Lead Local Flood Authority (Kirklees Flood Management & Drainage) Statutory Consultation

Consultation on Application Number: 2017/90620

Address: Dobroyd Mills, Hepworth Road, New Mill, Holmfirth, HD9 1AF

Proposal: Hybrid application - Planning application for demolition of existing buildings and erection of 2no workshop and ancillary office buildings (B1c/B8 use class) comprising a floor area of 880m² including mezzanine space, parking, access details and ancillary works. Outline planning application for the erection of up to 75no dwellings (Amended Description)

Title
FLOOD MODEL DRAWING

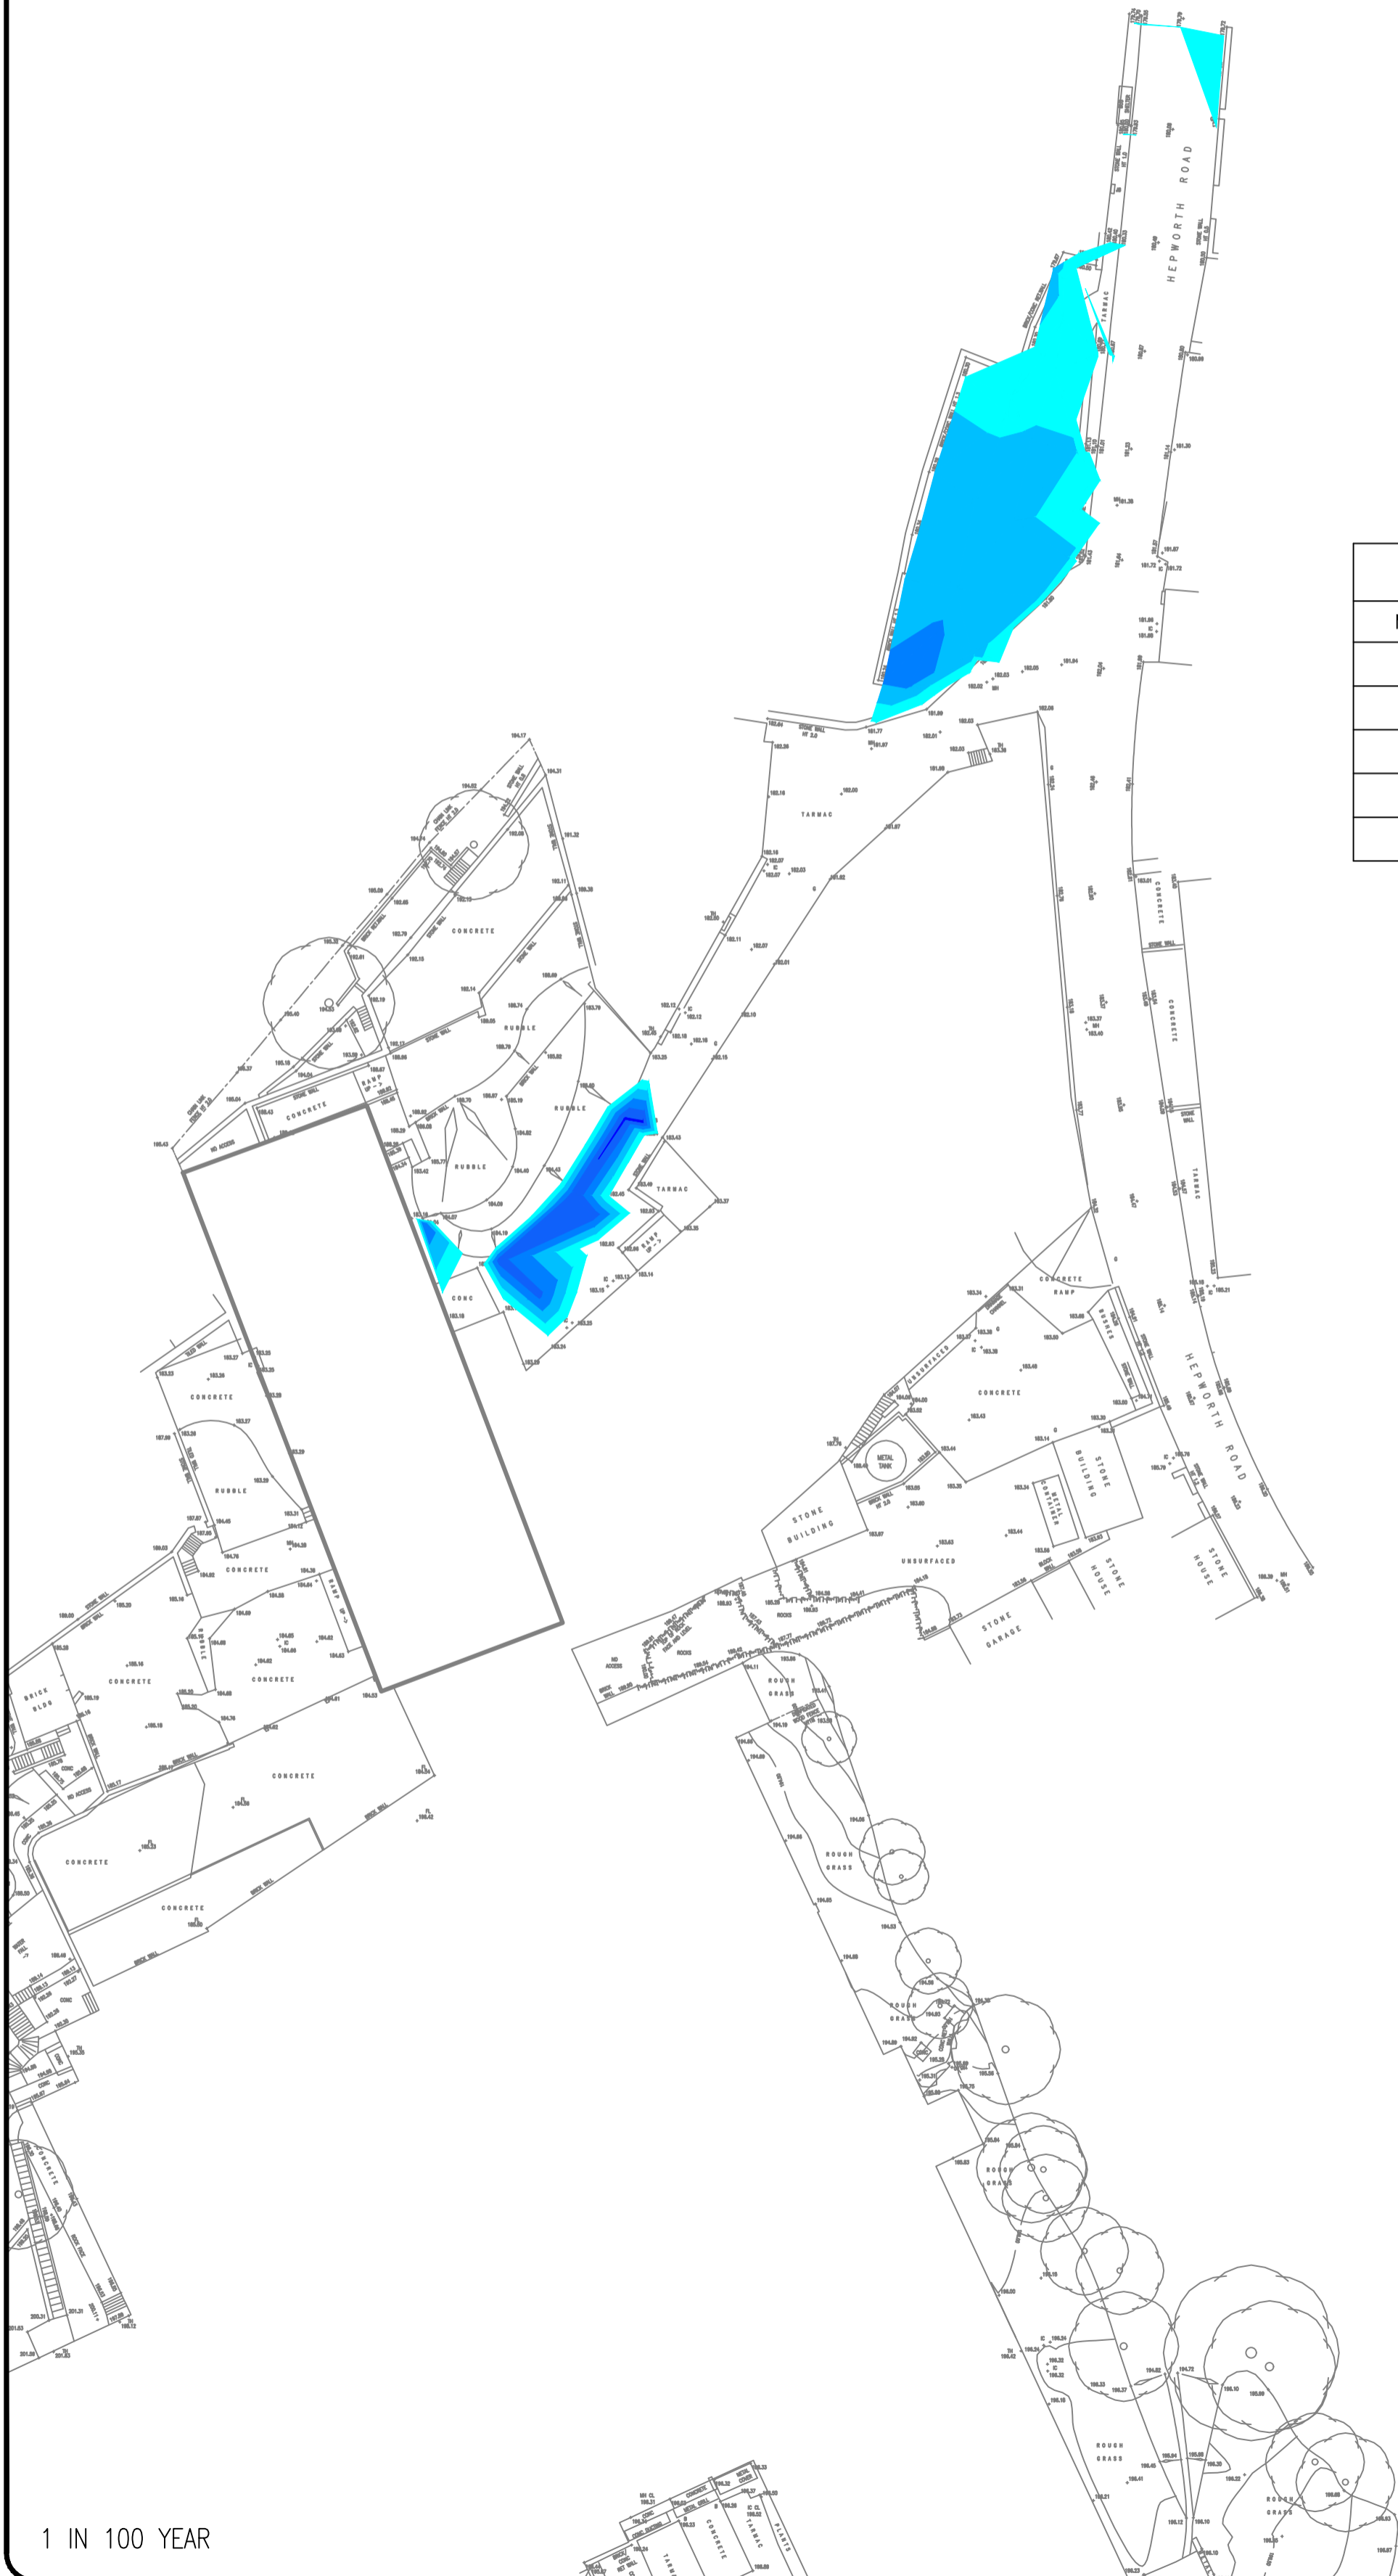
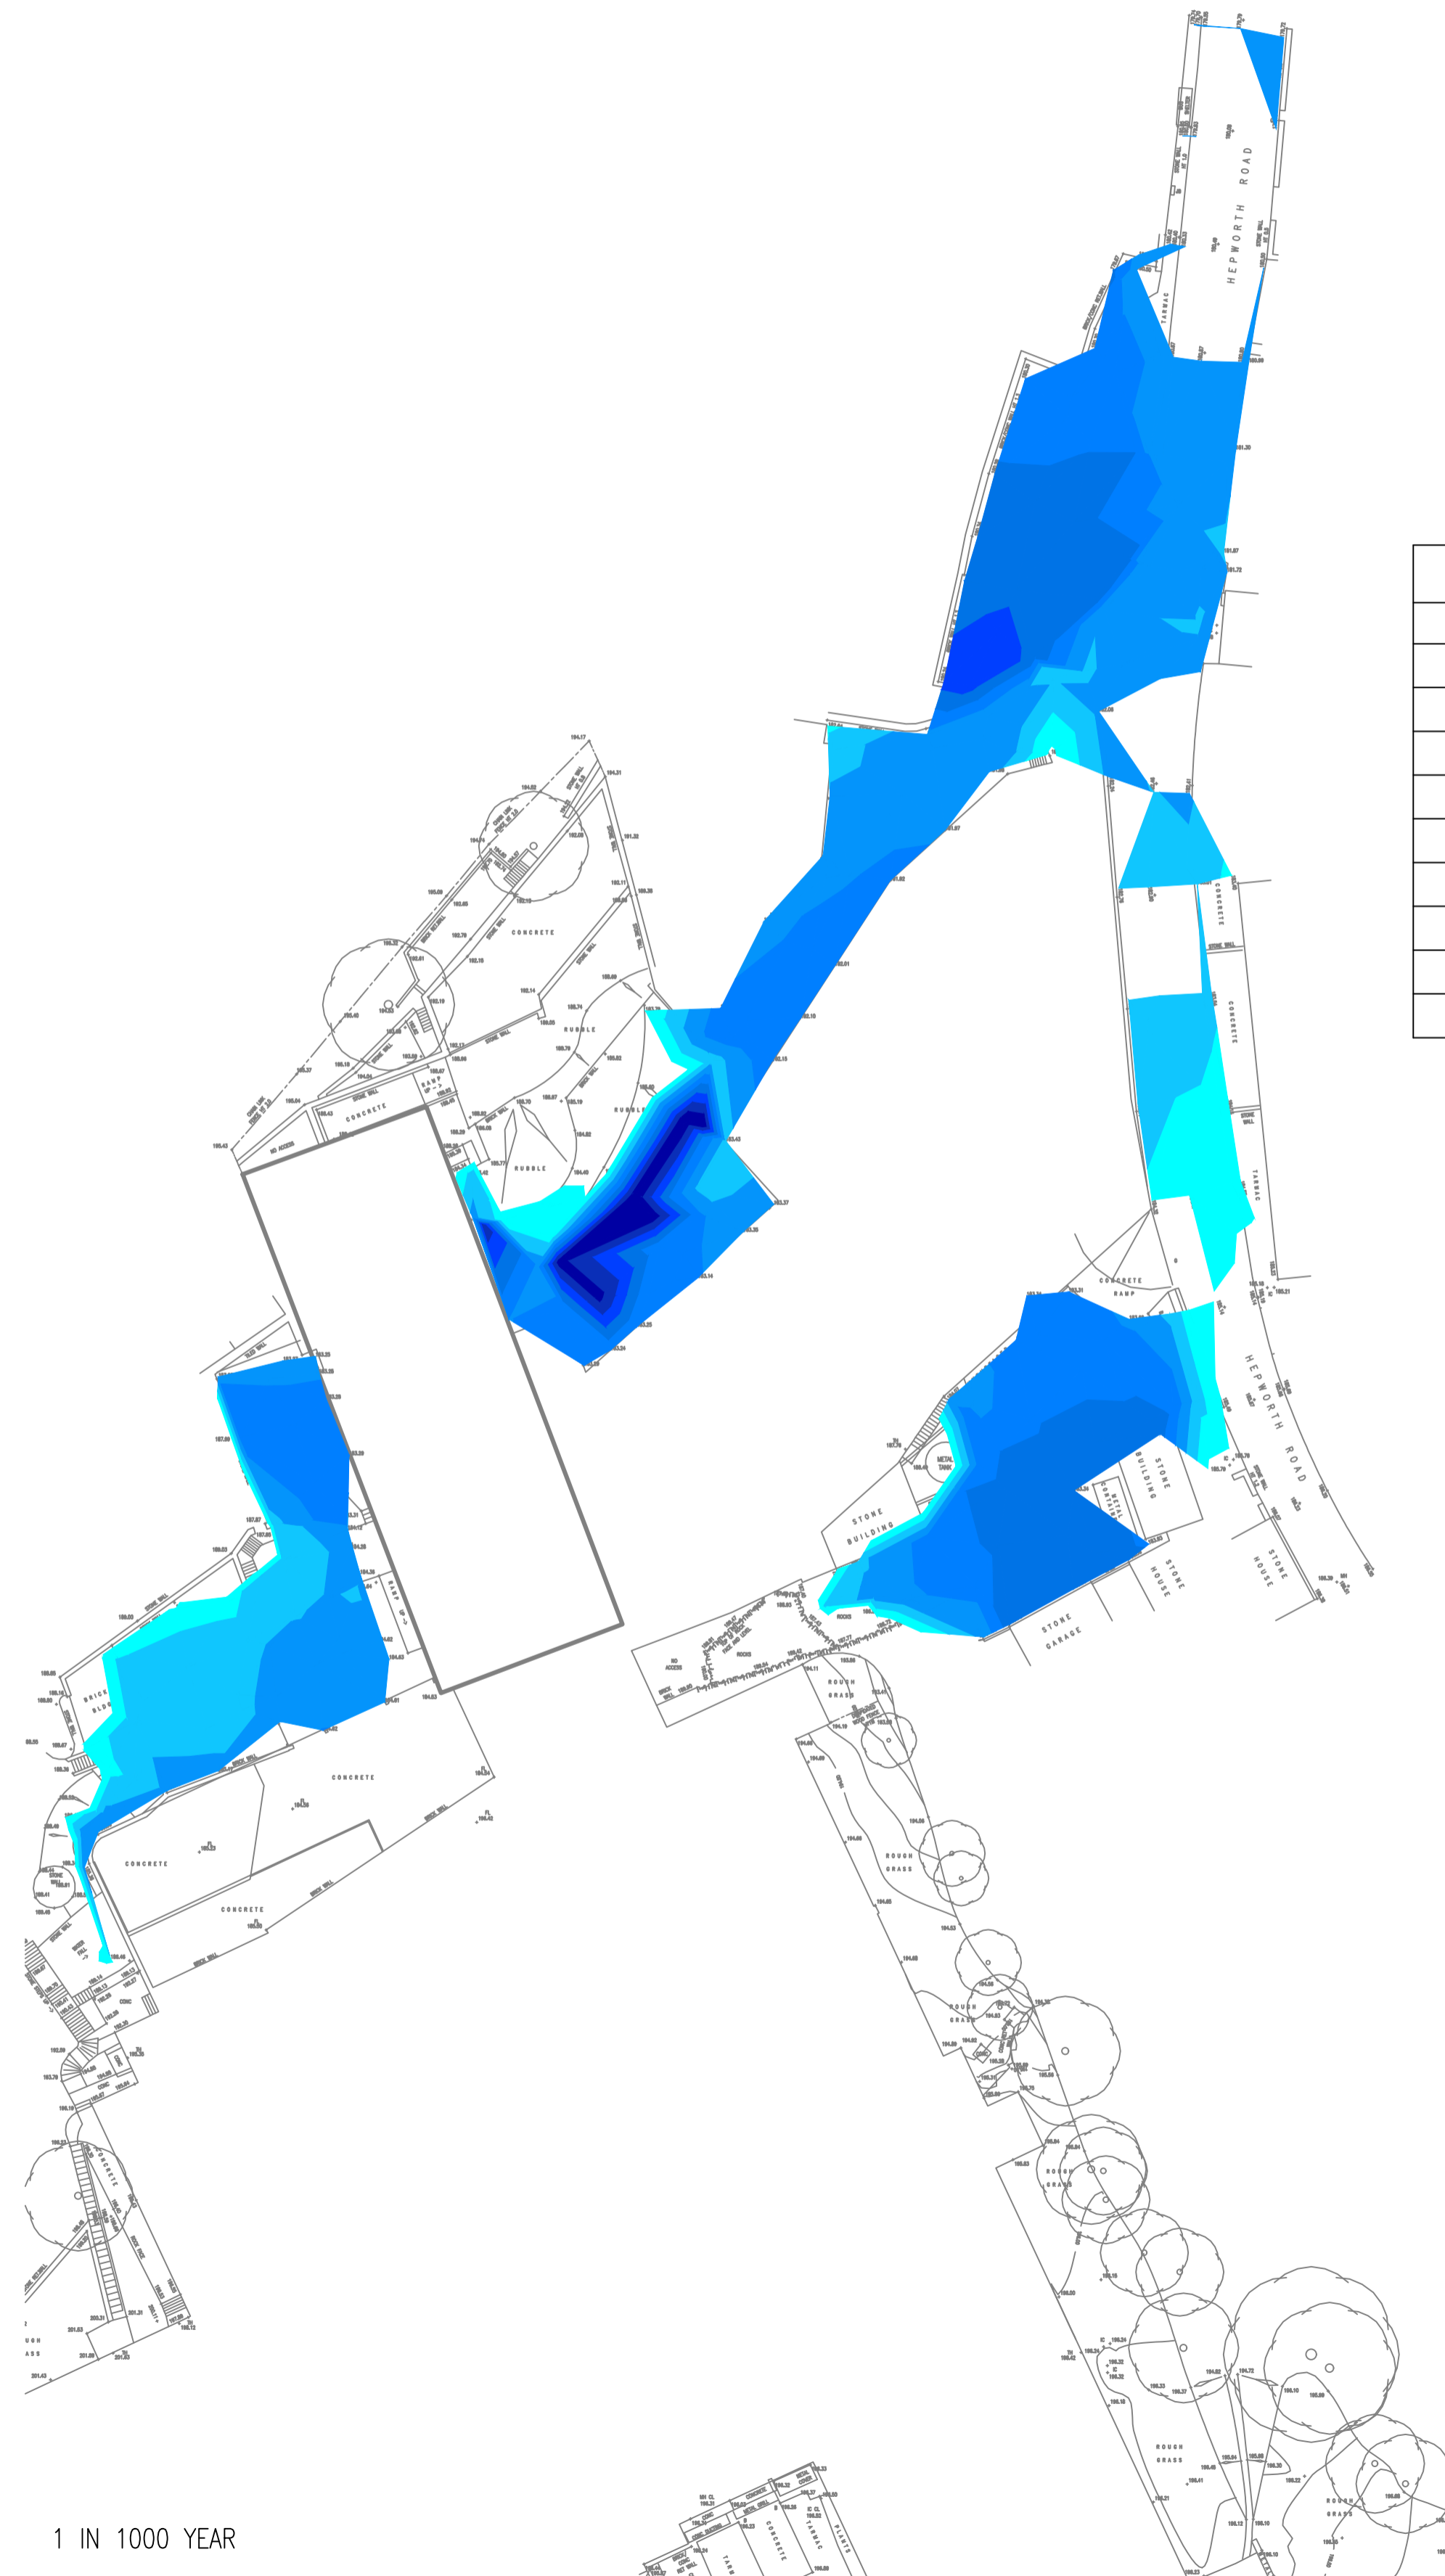
An addendum to the FRA has been provided. The Environment Agency should comment on the flood levels given for a 1D analysis which suggests that the model for Jackson Bridge Dike is incorrect.

The Environment Agency have provided 1 in 100 and 1 in 1000 year flood levels along Jackson Bridge Dike. The proposed FFL for both buildings is at least 3m higher than these levels.

We politely suggest to examine upstream of this area to see if main river flooding would escape out of channel and have a chance of running overland (2D modelling) providing a flood risk not discussed in the FRA. The Environment Agency may deem this unnecessary.
